RE: SP-23-00008, Rarden Short Plat
I-90 Exit 74, West Nelson Siding Road, Vicinity

RE: SP-23-00008 Rarden

TO: All Staff
FROM: Public Works Plan Review Team
DATE: November 16th, 2023
SUBJECT: SP-23-00008 Rarden

RARDEN SHORT PLAT
 A PORTION OF THE EAST 1/2 OF SECTION 20,
 TOWNSHIP 20 NORTH, RANGE 14 EAST, W.M.,
 KITTITAS COUNTY, WASHINGTON

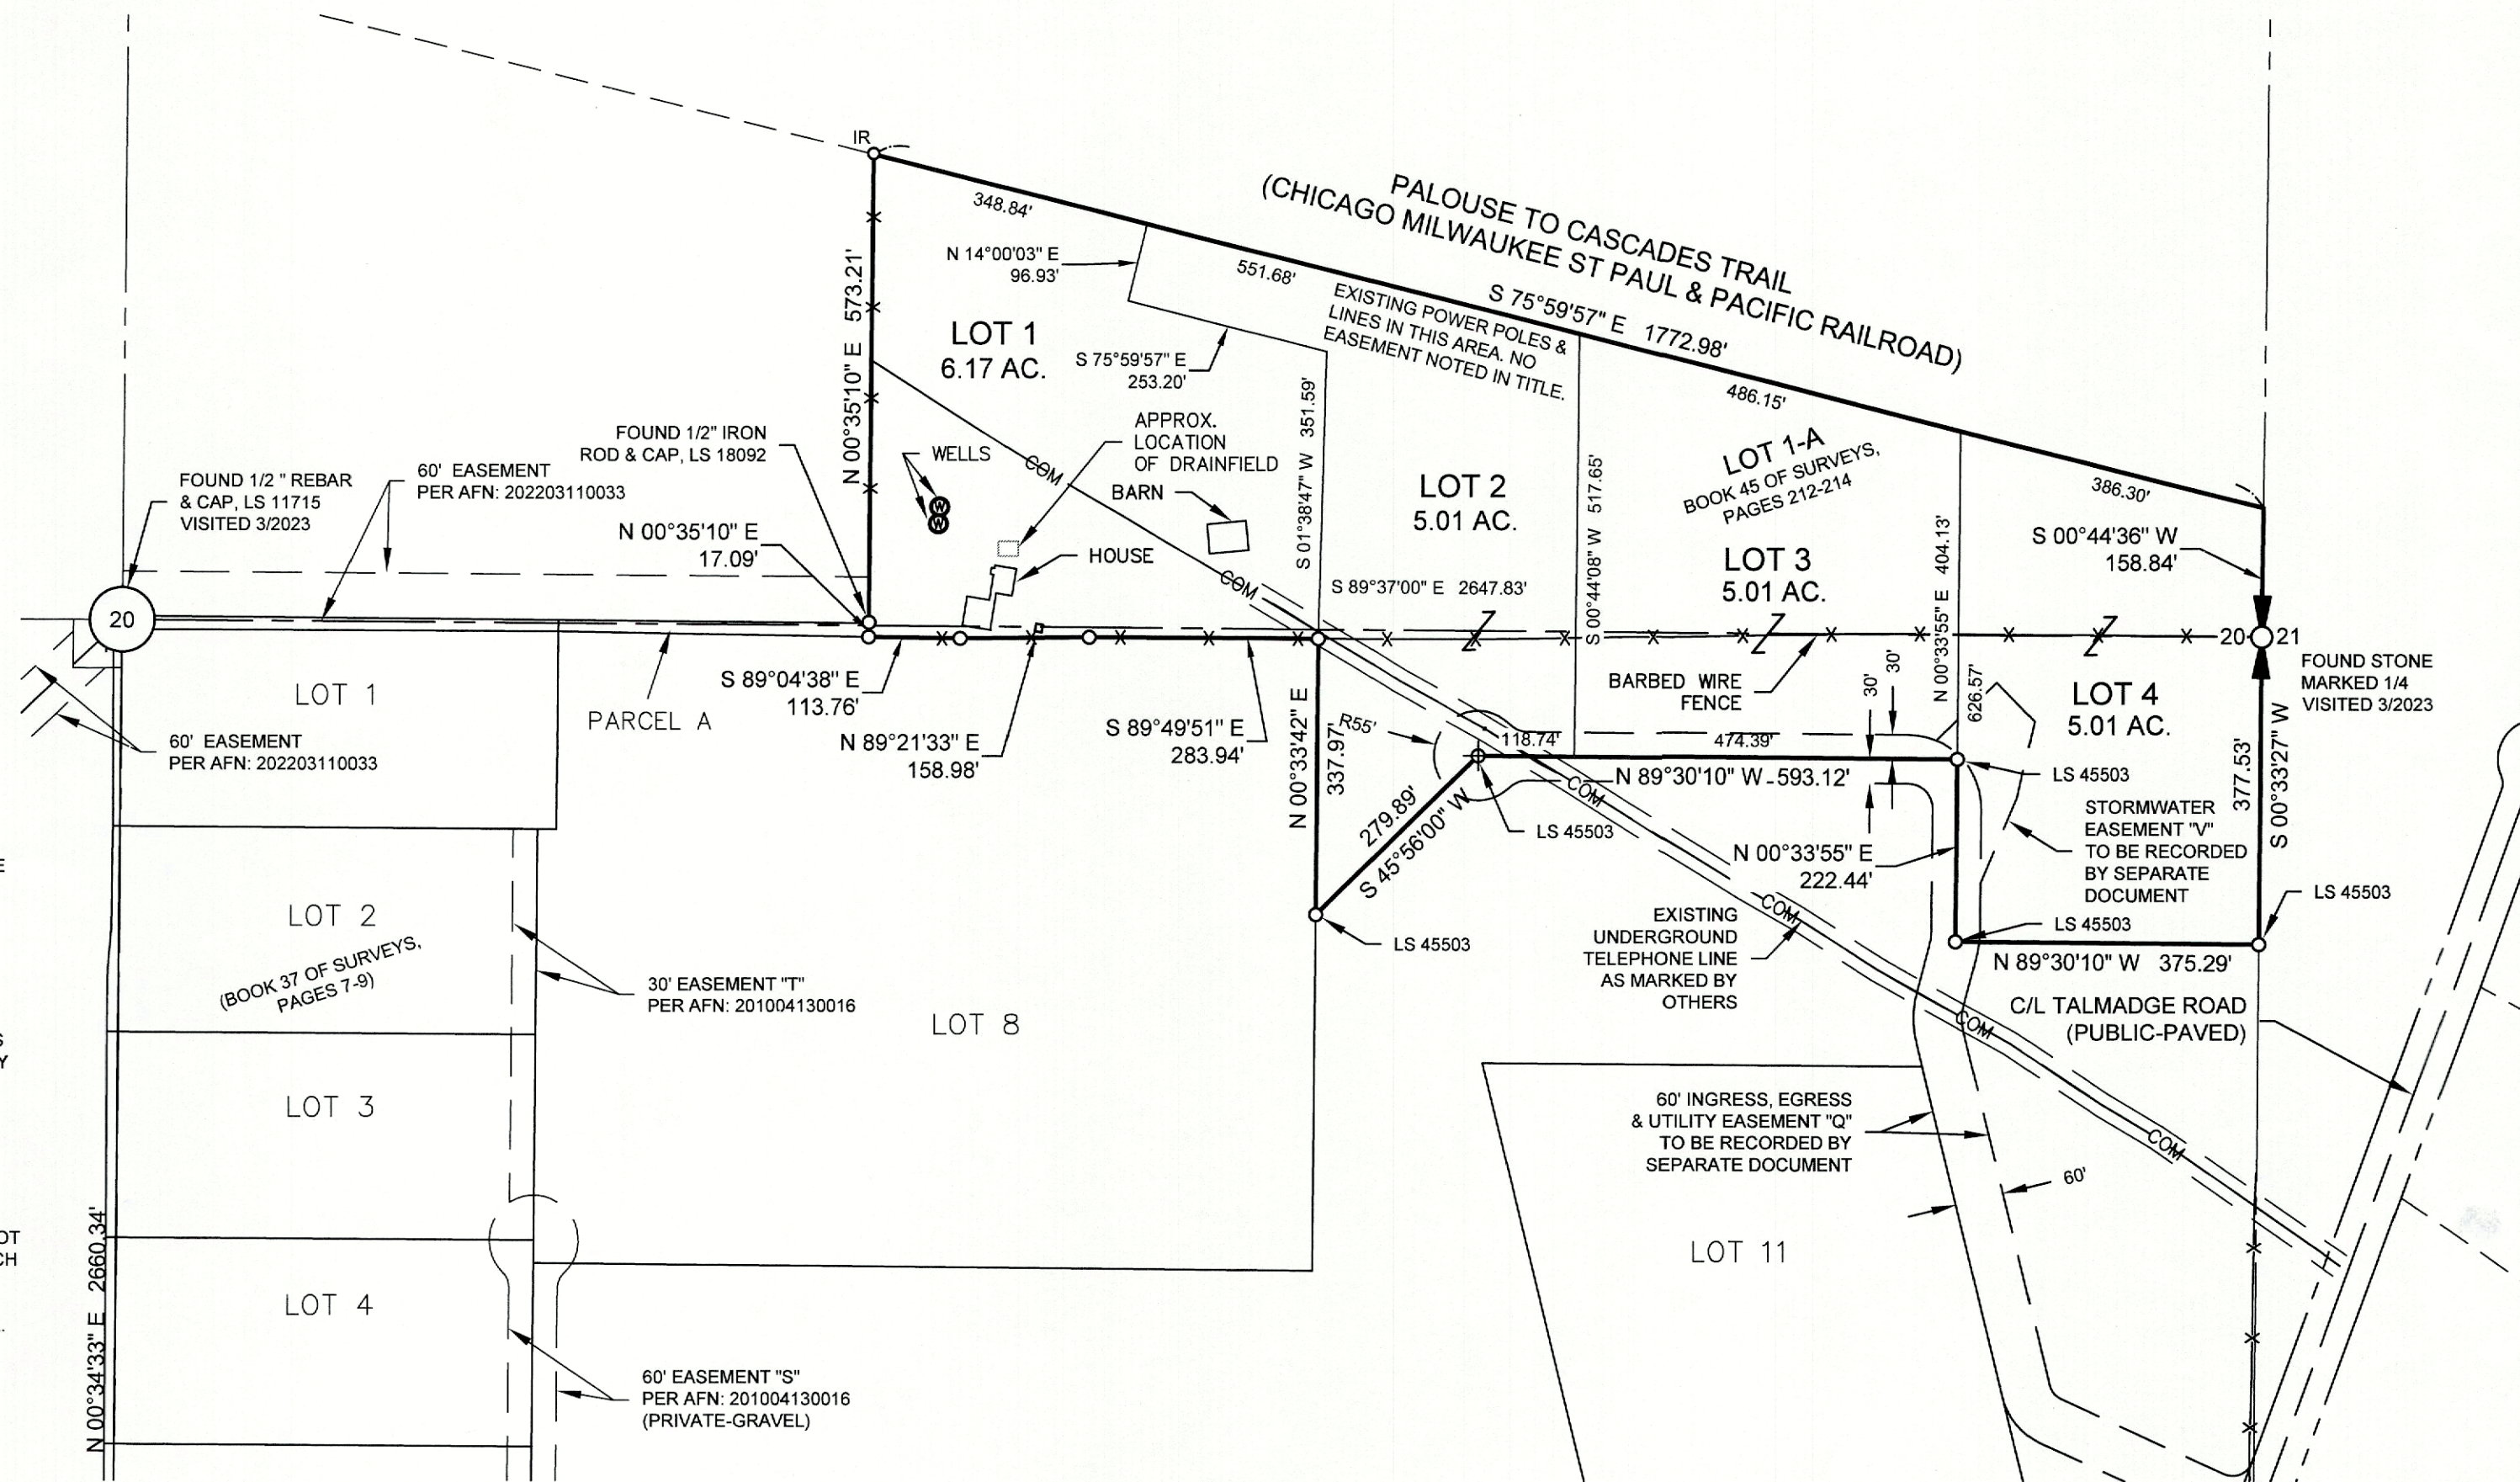
<p>ENGINEERING</p>	<p>Grading Permit GP-23-00011 was issued on 7/28/23. Please call for an inspection when the project is complete. (CC)</p>
<p>SURVEY</p>	<p>The following will need to be addressed prior to Final Short Plat approval:</p> <ol style="list-style-type: none"> 1. Per Note 1, Sheet 1, access to Lot 1A is Via a private easement. This should be changed to Lot 1, and the easement(s) shown in full. If there are gaps (as shown) in the NW1/4 and SE1/4 of the section, note that access is by prescription in these areas. 2. Notes 6, 8 and 9 all reference different basis of bearings statements, and make references to Lots not shown on the face of the Short Plat.

<p>Please resolve, and if multiple Basis of Bearing were utilized, please include the rotation and direction (clockwise or counterclockwise), that was used to put it in the final rotation shown on the map.</p> <p>3. The SW'most corner of Lot 2 will need to be set and shown on the face of the Final Survey.</p>
TRANSPORTATION CONCURRENCY	<p>A Transportation Concurrency Management Application has been submitted. Permit #: TC-23-00005 This permit will need to be finalized before final approval.</p>
FLOOD	<p>Parcel # 415436 is not located in the FEMA identified special flood hazard area (100-year floodplain). (SC)</p>
WATER MITIGATION/ METERING	<p>The following comments outline the requirements for legal availability of water and metering for the proposed short plat:</p> <p>The applicant must provide legal water availability for all new uses on the proposed lots of this project, which can be provided through mitigation certificates. Prior to final plat approval and recording, the following conditions shall be met:</p> <p>In accordance with KCC Chapter 13.35.027, the applicant shall provide one of the following documents before final plat approval:</p> <ol style="list-style-type: none"> 1. A letter from a water purveyor stating that the purveyor has adequate water rights and will provide the necessary water for the new use; 2. An adequate water right for the proposed new use; or 3. A certificate of water budget neutrality from the Department of Ecology or other adequate interest in water rights from a water bank. <p>All applicants for land divisions shall also submit information on "proximate parcels" held in "common ownership" as those terms are defined in WAC 173-539A-030 and otherwise demonstrate how the proposed new use will not violate RCW 90.44.050 as currently existing or hereafter amended.</p> <p>Failure to obtain mitigation before commencement of an activity requiring mitigation shall be a code violation subject to enforcement under Title 18 KCC.</p> <p>Final Plat Notes</p> <p>The following notes shall be placed on the face of the plat:</p> <p>C-1 "Metering is required for all new uses of domestic water for residential well connections and usage must be recorded in a manner consistent with Kittitas County Code Chapter 13.35.027 and Ecology regulations."</p> <p>C-2 "The approval of this division of land provides no guarantee that use of water under the ground water exemption (RCW 90.44.050) for this plat or any portion thereof will not be subject to curtailment by the Department of Ecology or a court of law." (SC)</p>
